18 March 2021

SF2018/318466; WST18/00146/06

SSD-10419: consolidated mining lease (CML) 6, mining purposes lease (MPL) 854 and mining lease (ML) 1483 and ML 1805; Kidman Way (MR410), Cobar- New Cobar Complex Project

Figure 15.4 Concept New Cobar Complex heavy vehicle access intersection upgrade

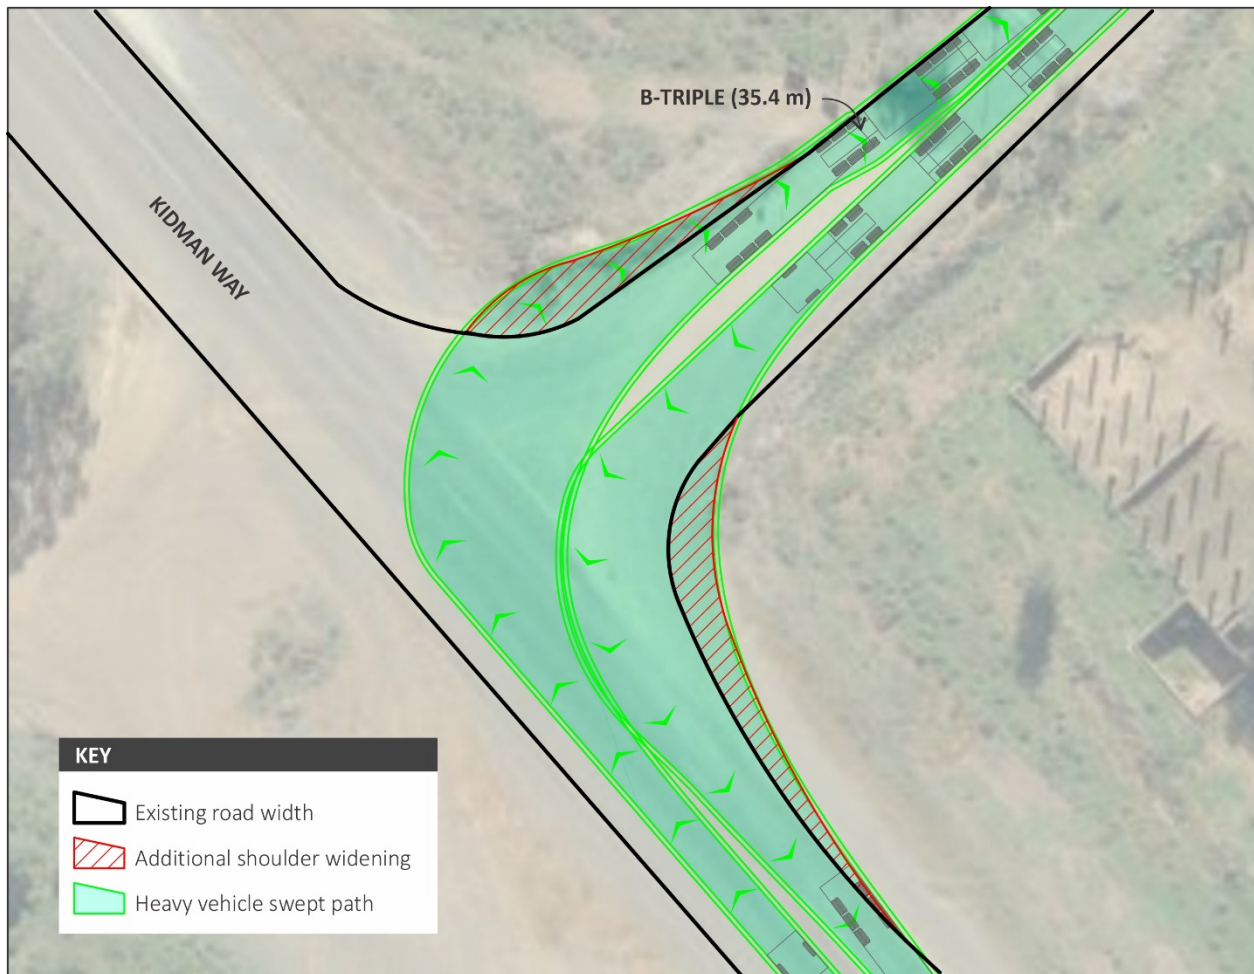
- No information has been provided on the construction related traffic generation component of the development. Whilst construction traffic may be less than the traffic generated by the operation of the development, it will utilise a different intersection with the Kidman Way to the operational traffic. In this regard, the following additional information is required to be provided:

- The largest vehicle (design vehicle) to use the construction access;
 - The daily and peak hour traffic generation (quantification and timing), for both light and heavy vehicles, for construction traffic;

- Trip origin and destination; and
 - Number of oversize vehicles.
- The DA documents outline the additional traffic likely to be generated as a result of the additional intensity proposed. However, as this approval will “replace” the existing approvals and also include the additional intensity, quantification of the total traffic generated by the development to be approved is required to be provided, both for peak daily traffic and peak hour traffic.
